Botley West Solar Farm – EN010147

Representation concerning the Applicant's latest submissions

From Interested Party: Steven Jenkins

Title  
 Landscape, Ecology and Amenities Plan

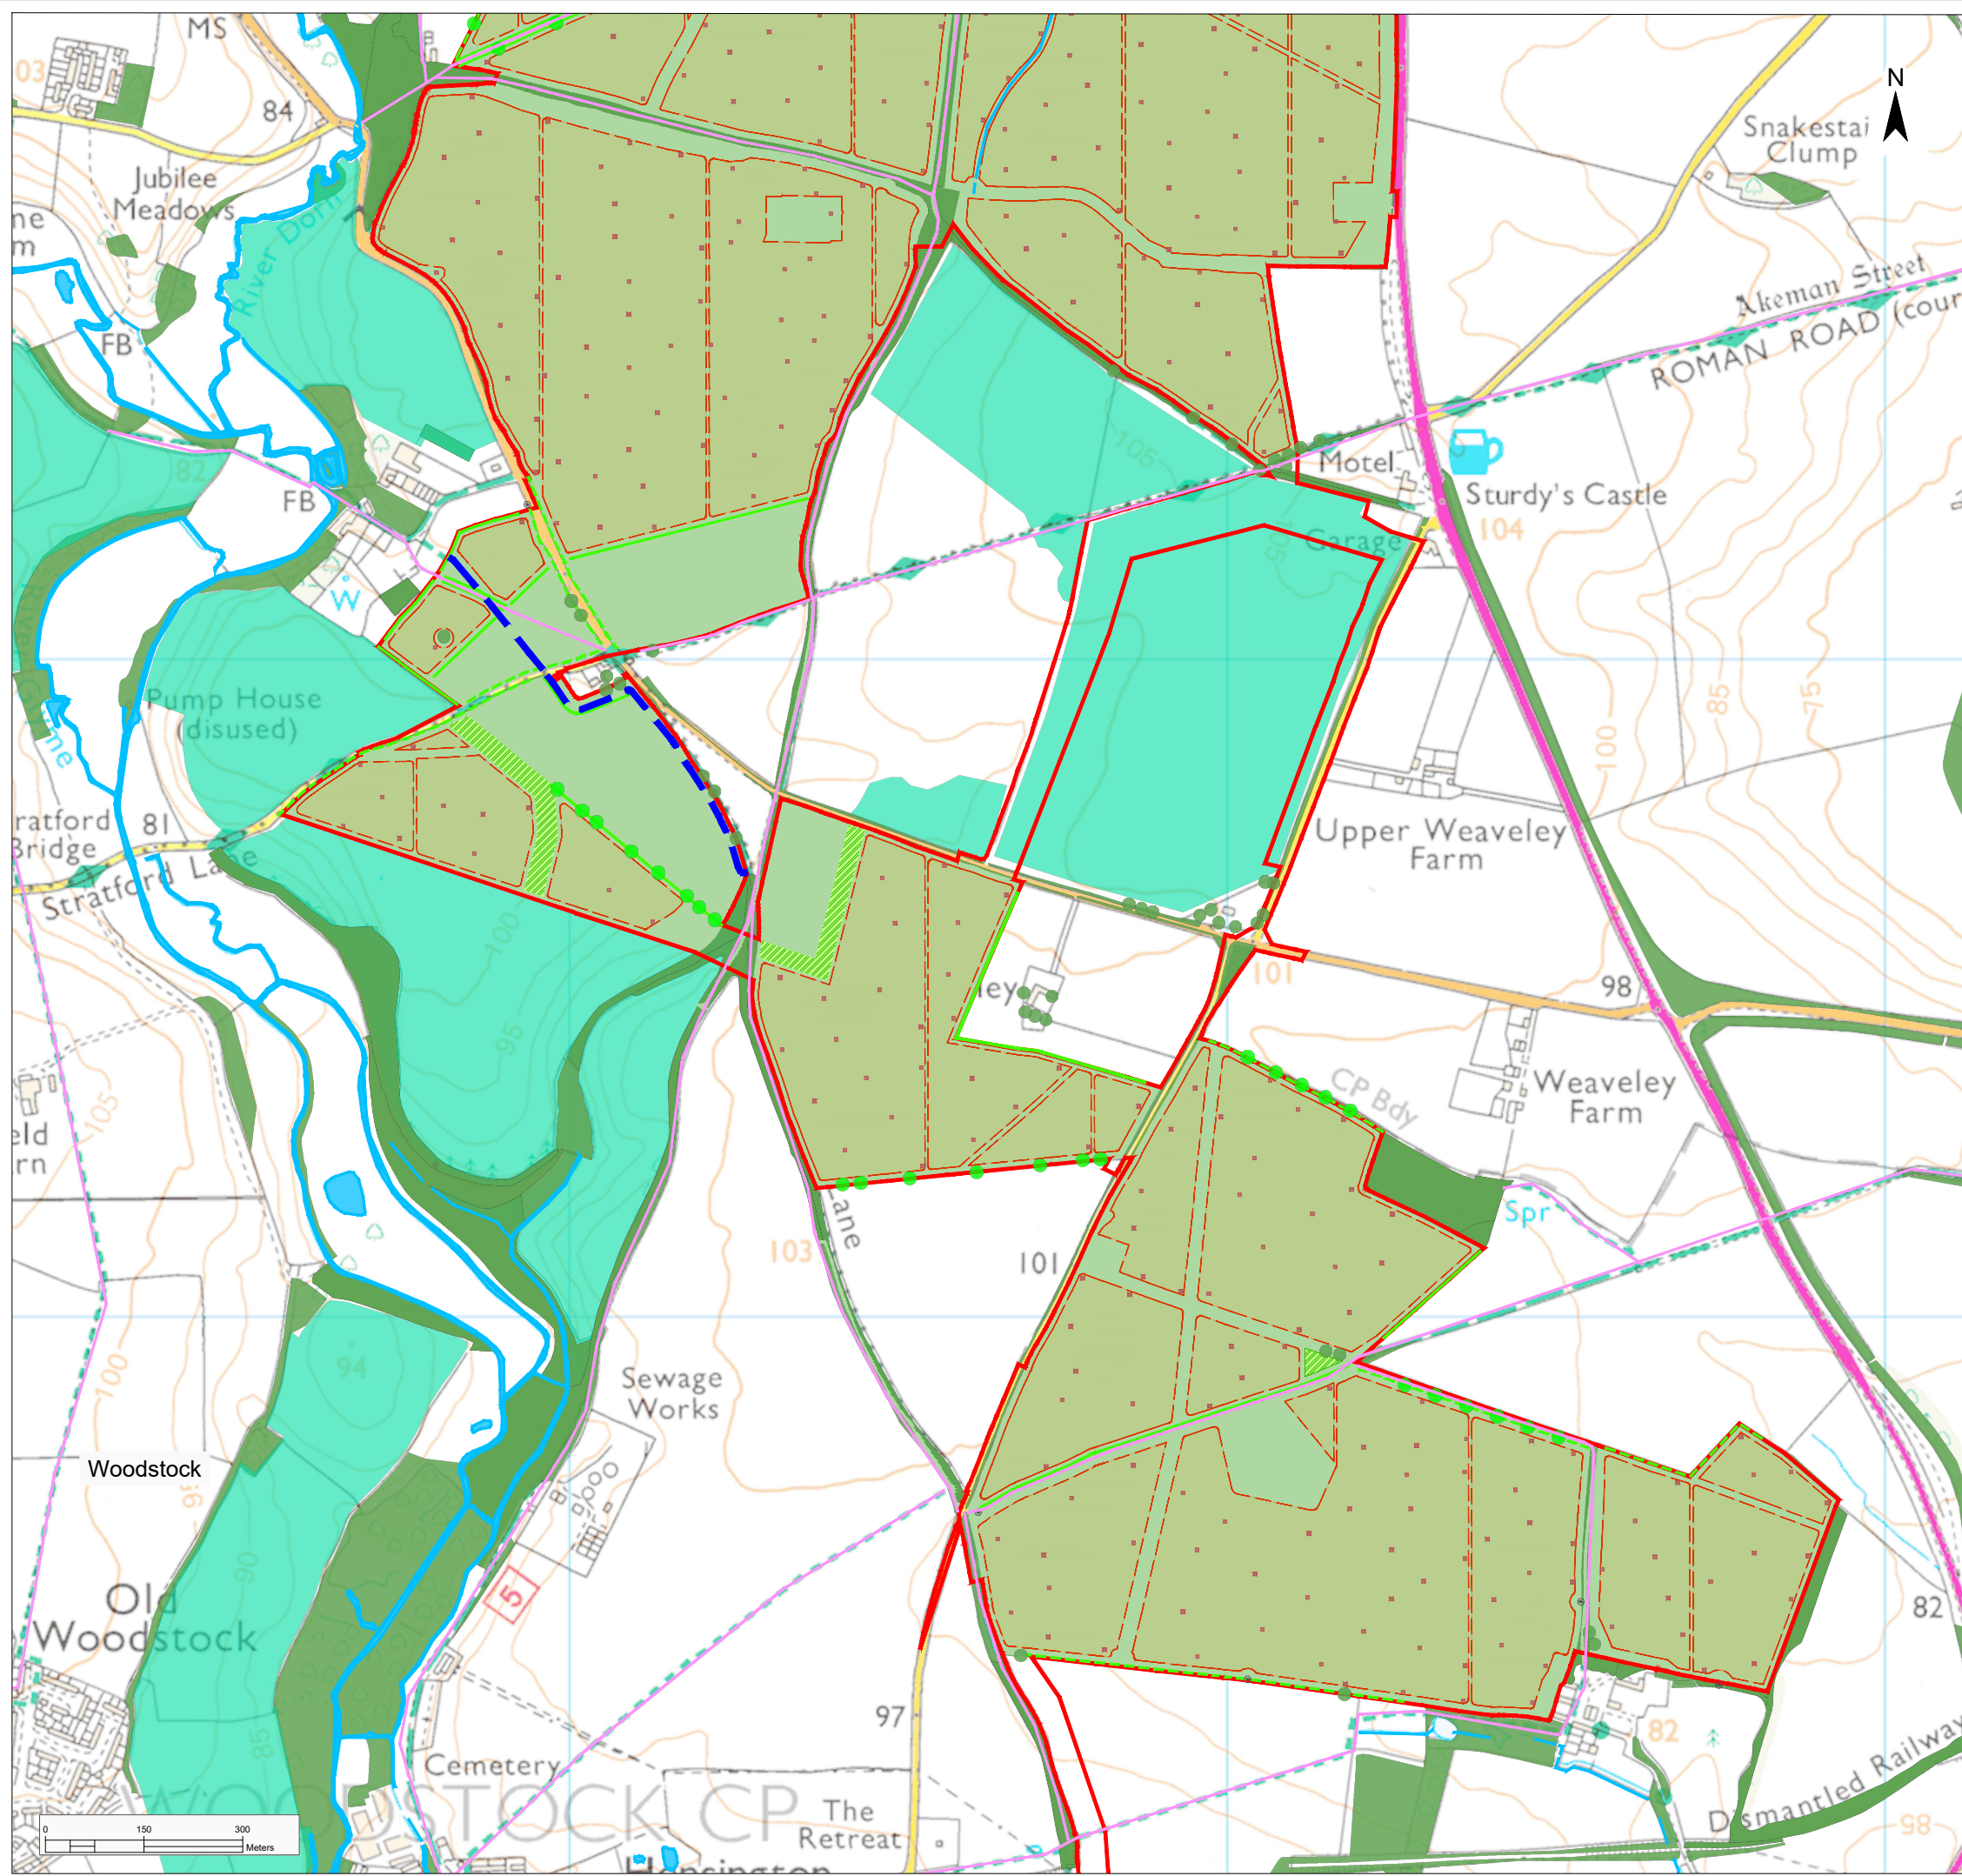
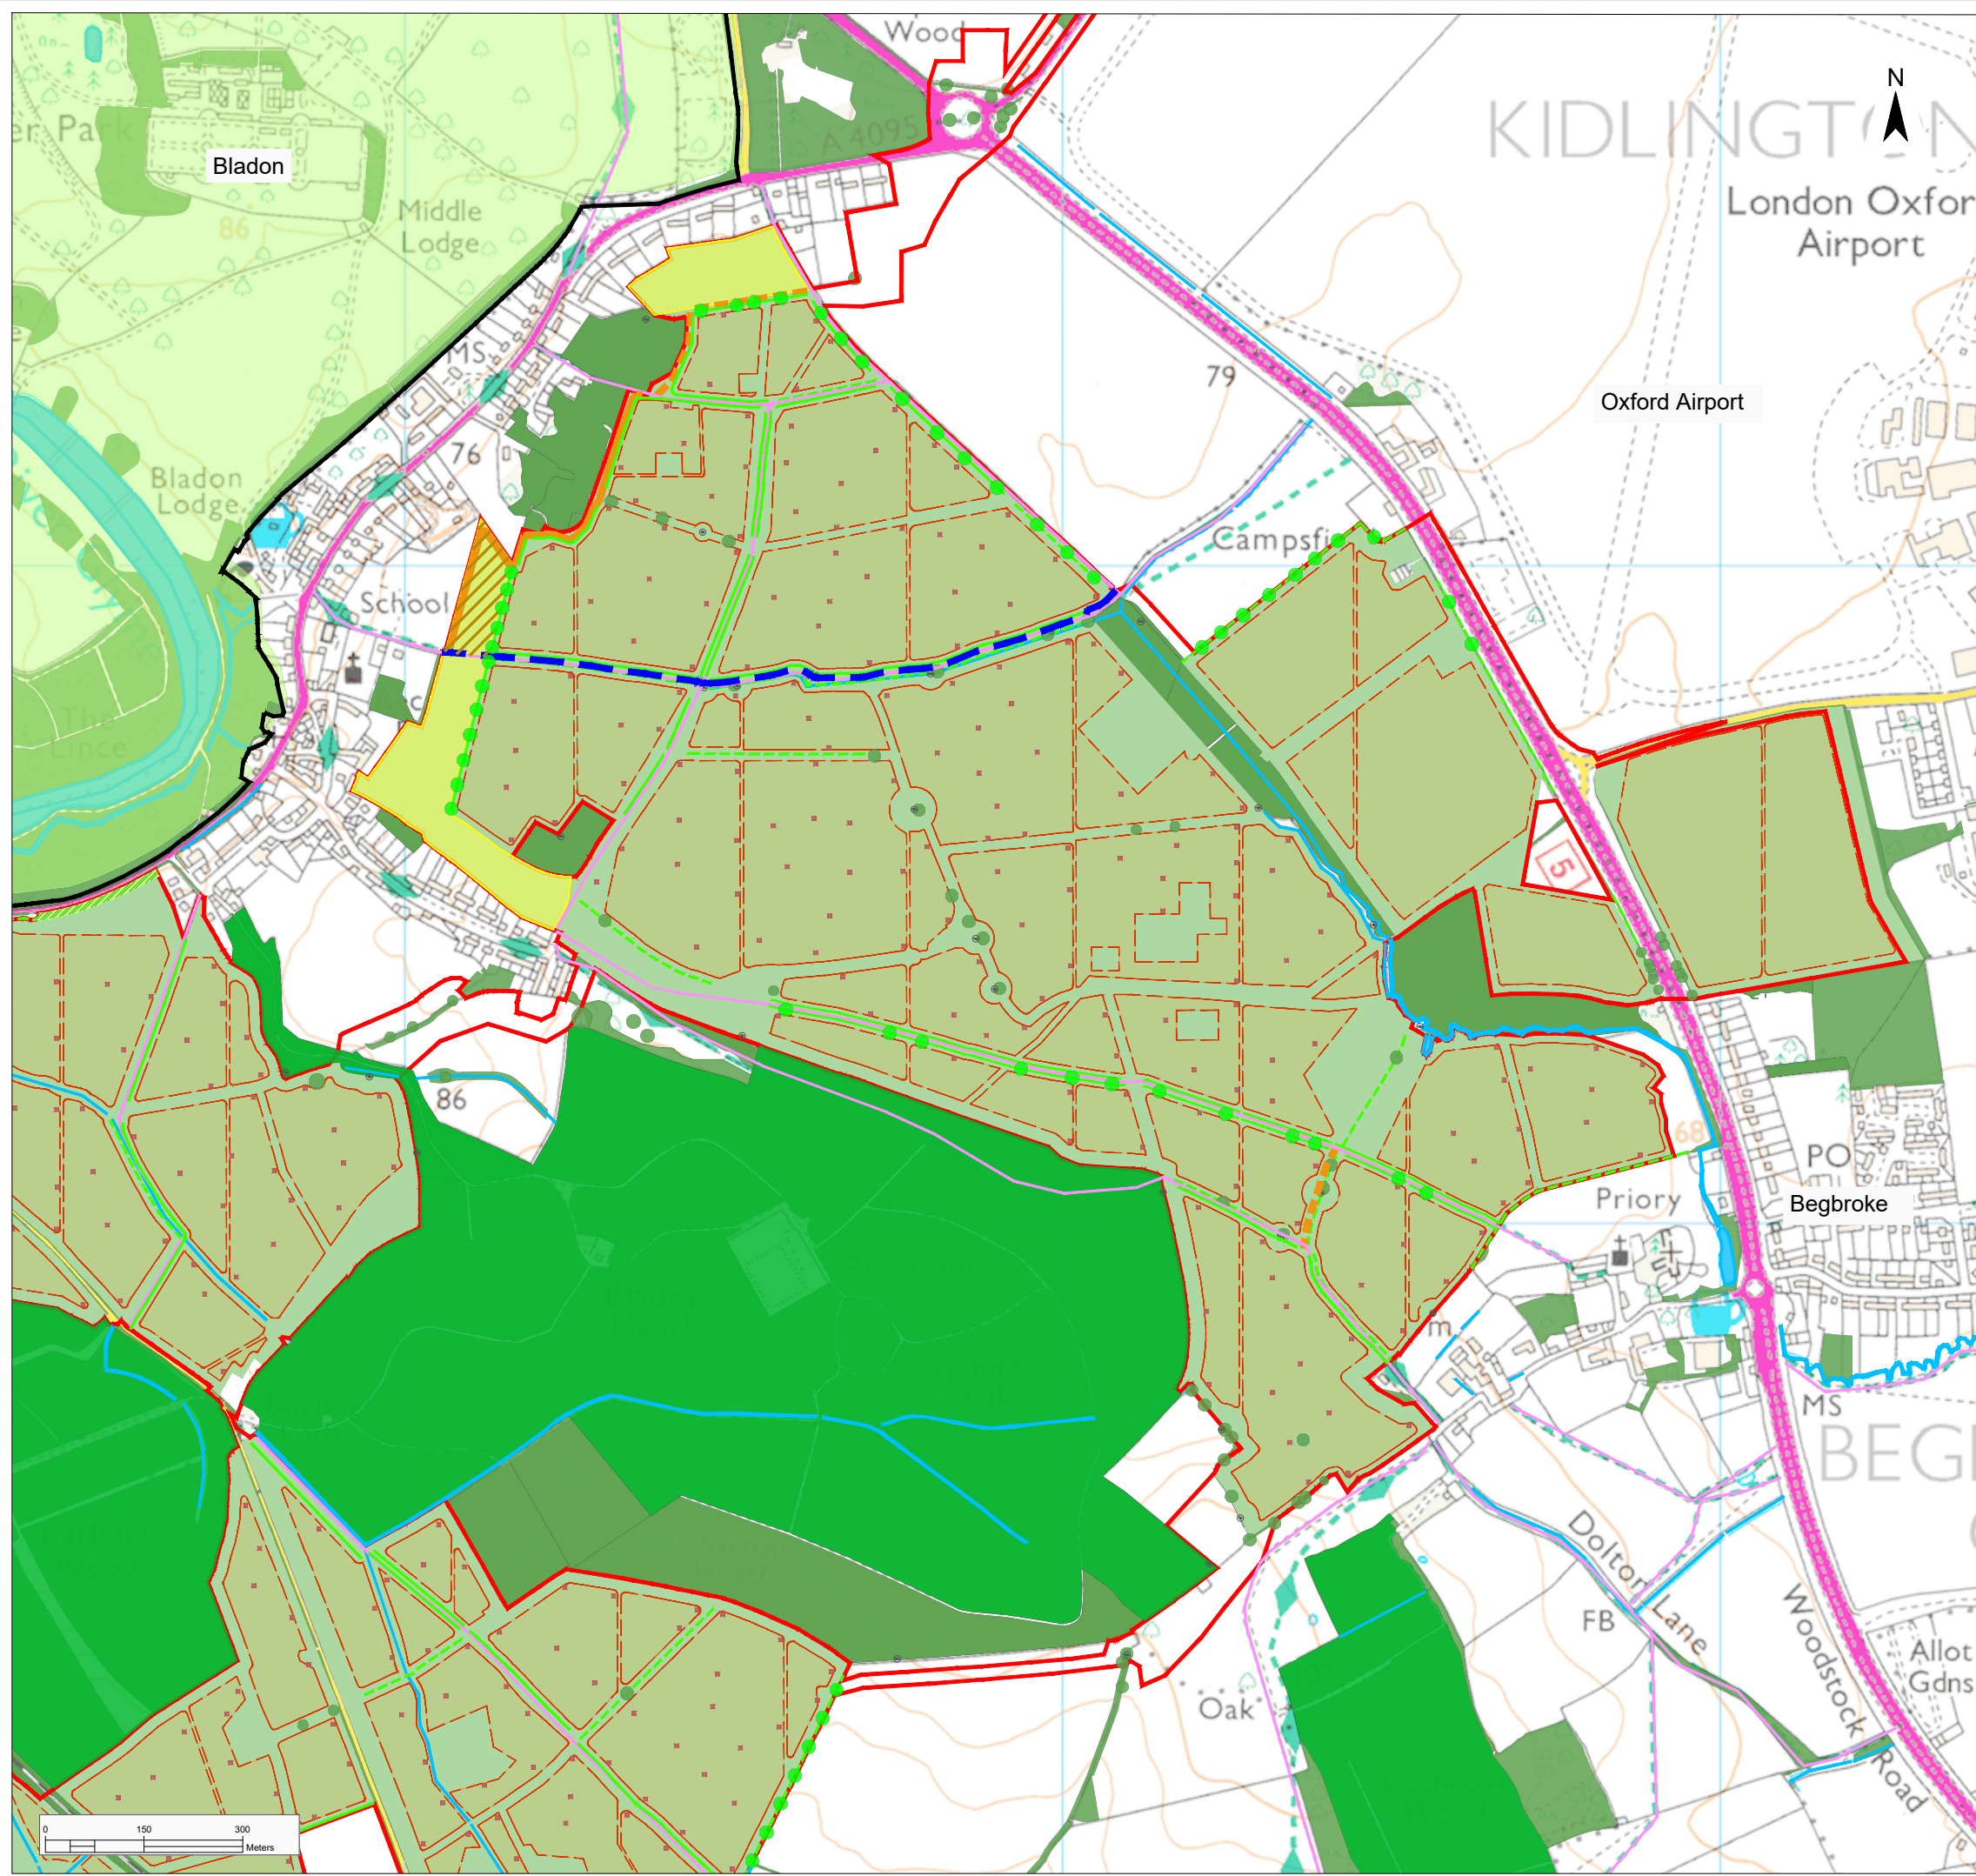
There appears to have been no further satisfactory resolution of the issue of **community food-growing areas**. The areas concerned should be removed from the red-line boundary, as previously raised in REP5-072, REP5-093 and REP6-076.
